## Fire Marshal Division

**Re: Campbell University School of Engineering Annex II**  
**108 Burt Street**  
**Buies Creek, NC 27506**

**Application Number FMFW1904-0012**

**LF-1**

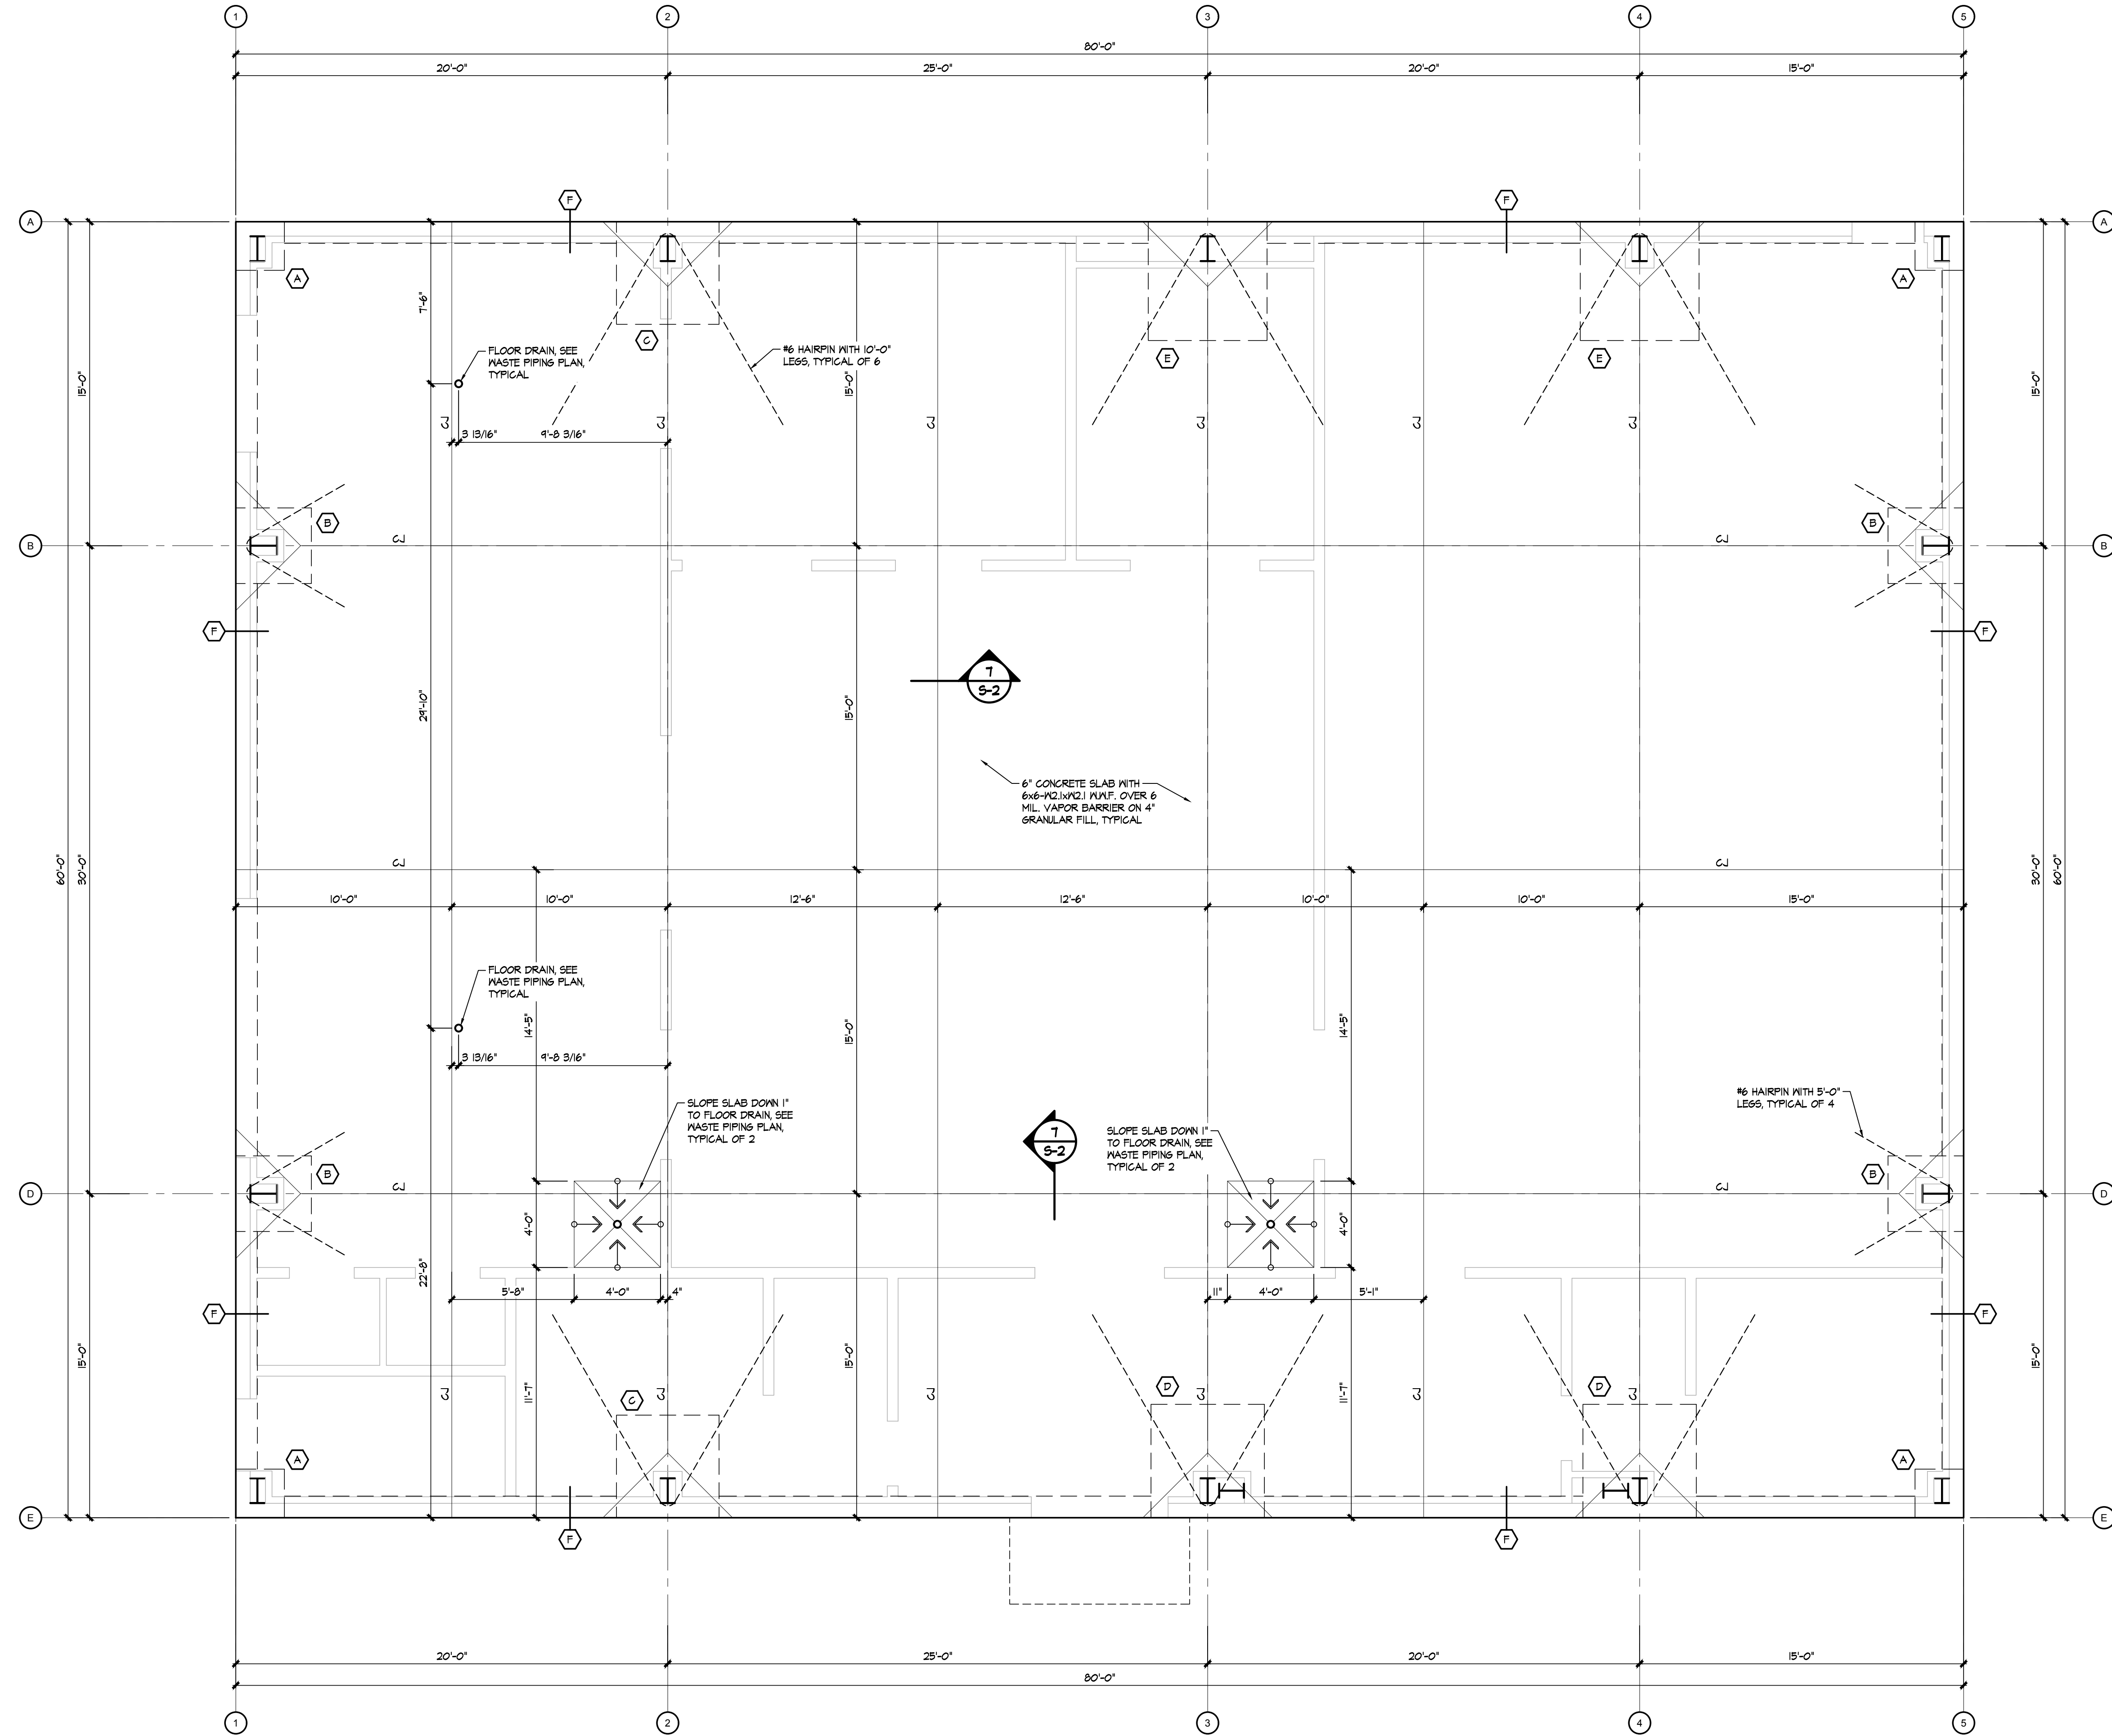
- **906.1 Fire Extinguishers required.**
  - A minimum 2A10BC classification of fire extinguisher is required on each floor and located so that the maximum travel distance to reach an extinguisher does not exceed 75ft.
  - Fire Extinguishers shall be located in approved cabinets along corridors.
  - All fire extinguishers shall be mounted not higher than 5ft. above the finished floor and in accordance with NFPA 10.

**ELECTRICAL LIGHTING PLAN**

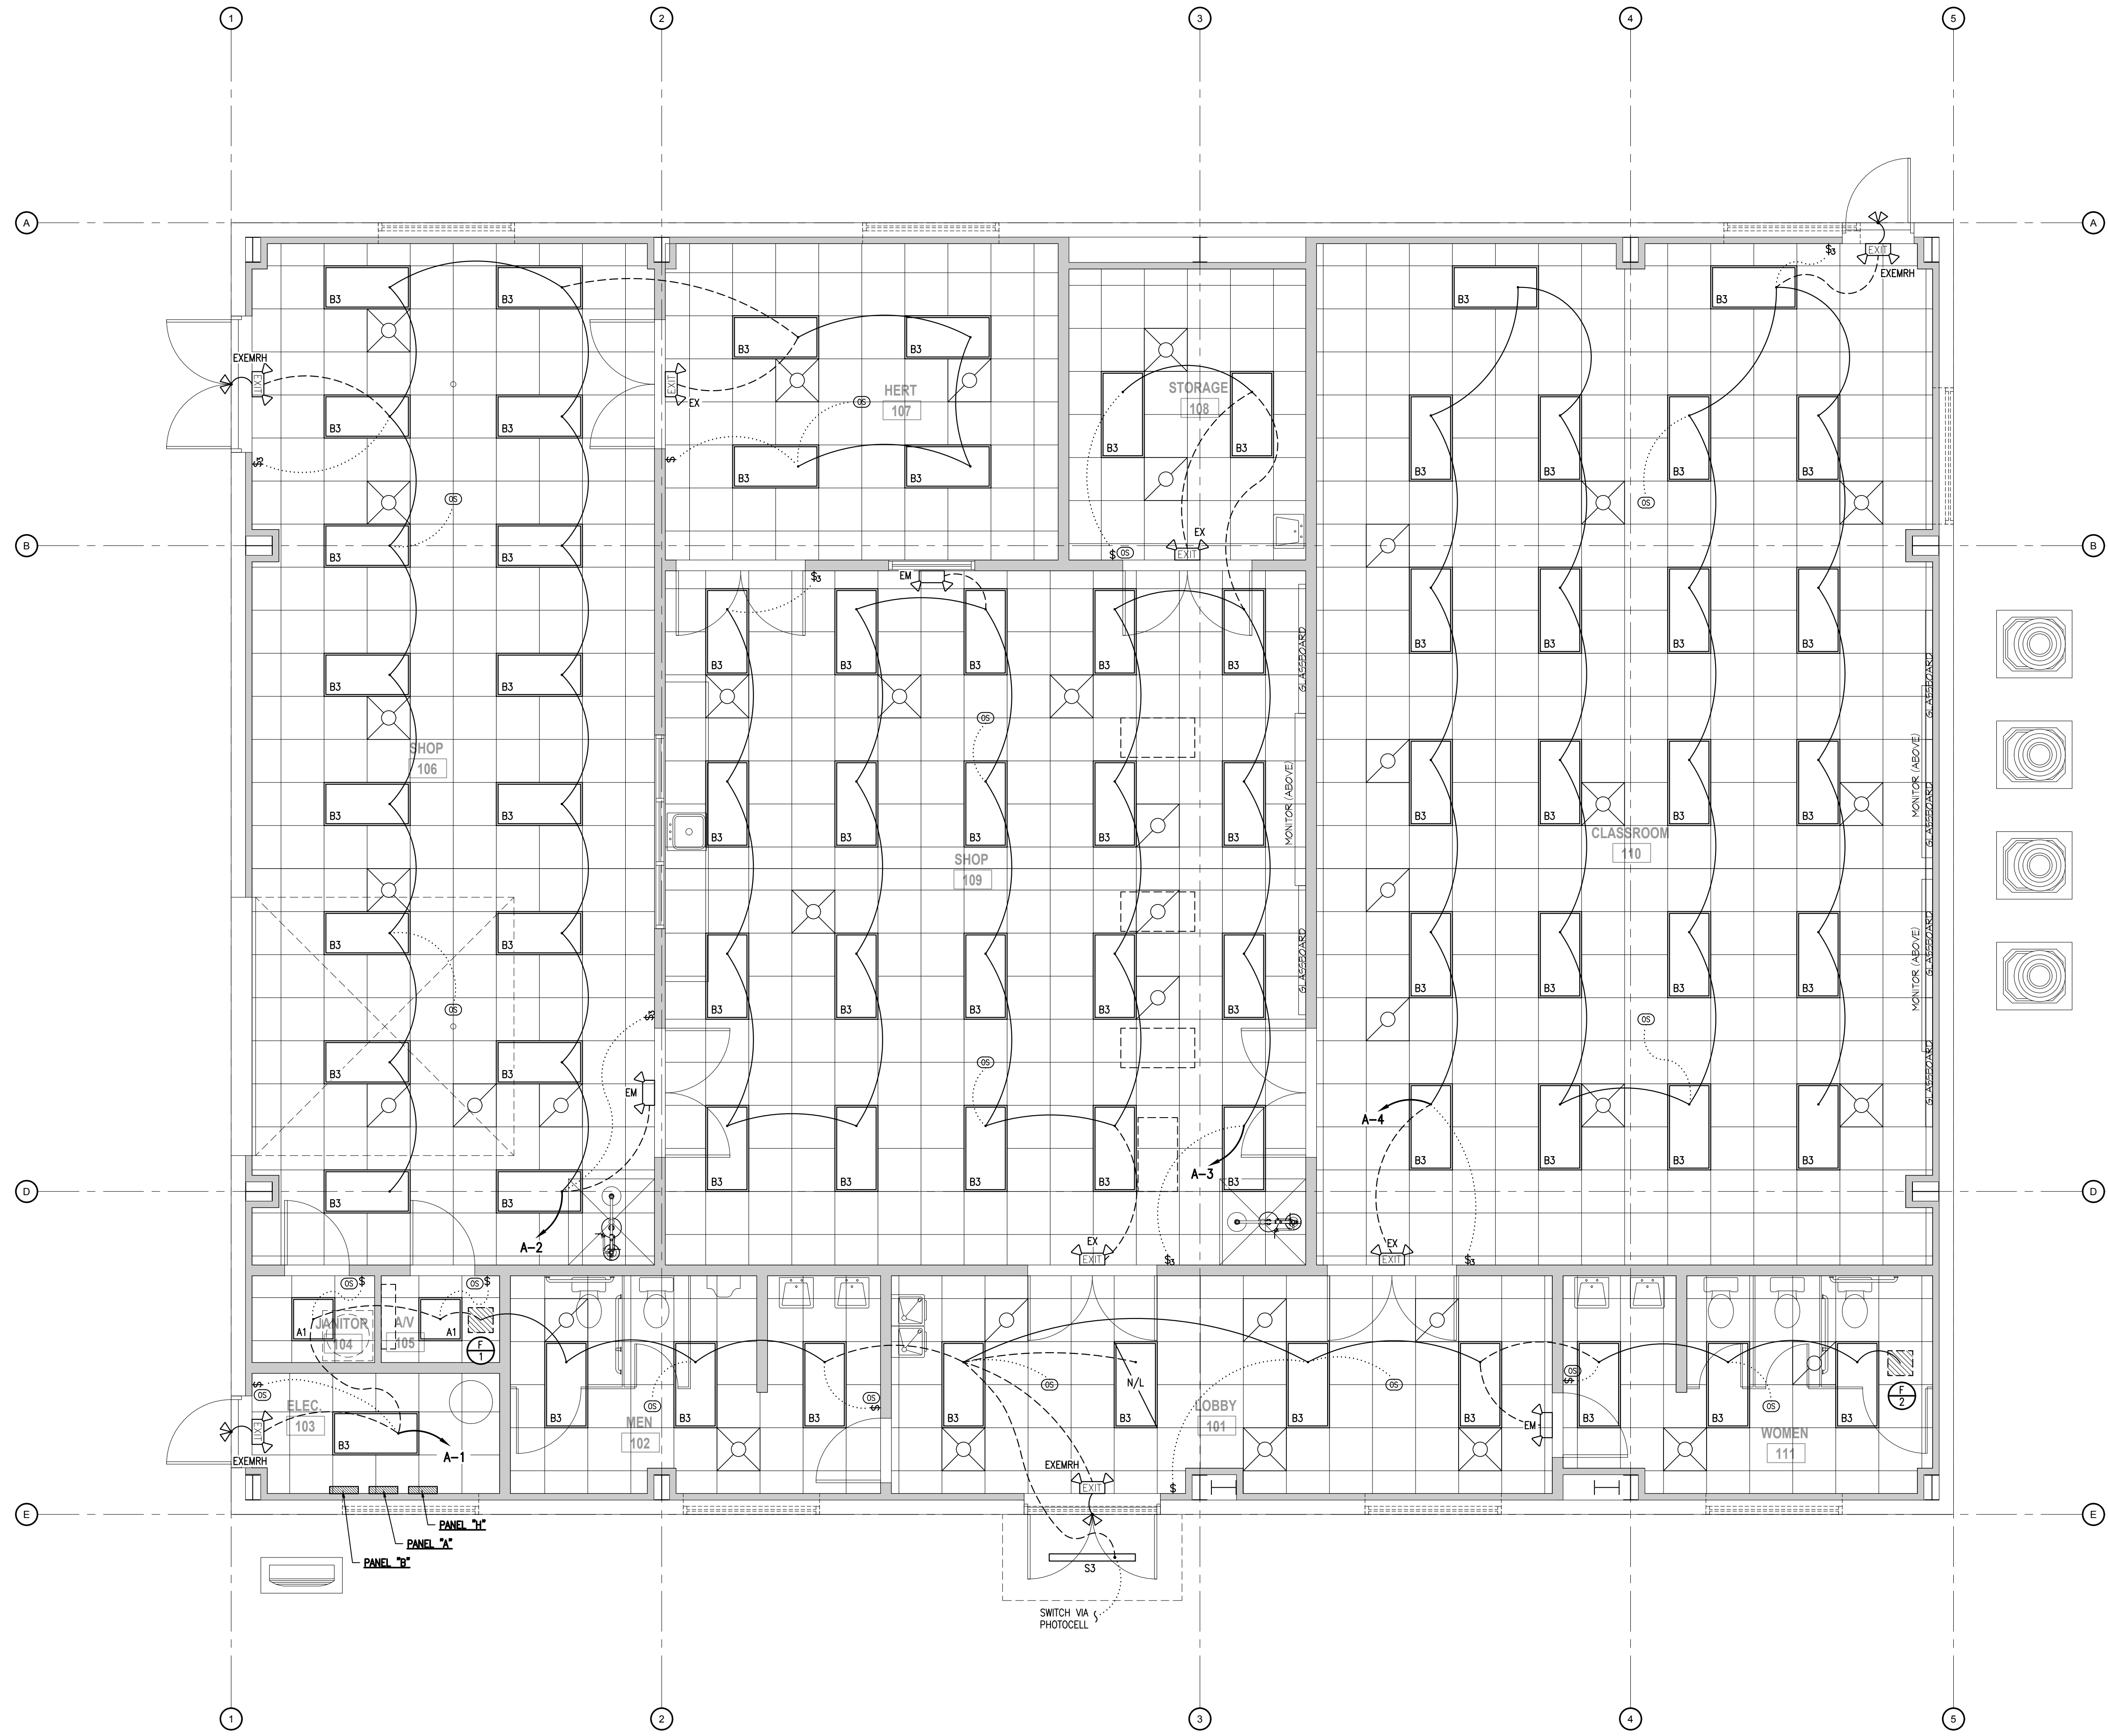
- **1006.1 Means of Egress Illumination**
  - The means of egress, including the exit discharge, shall be illuminated at all time the building space is served by the means of egress is occupied.
    - Means of egress consist of three separate and distinct parts: the exit access, the exit and the exit discharge.
  - The means of egress illumination shall not be less than 1 foot-candle at the walking surface.
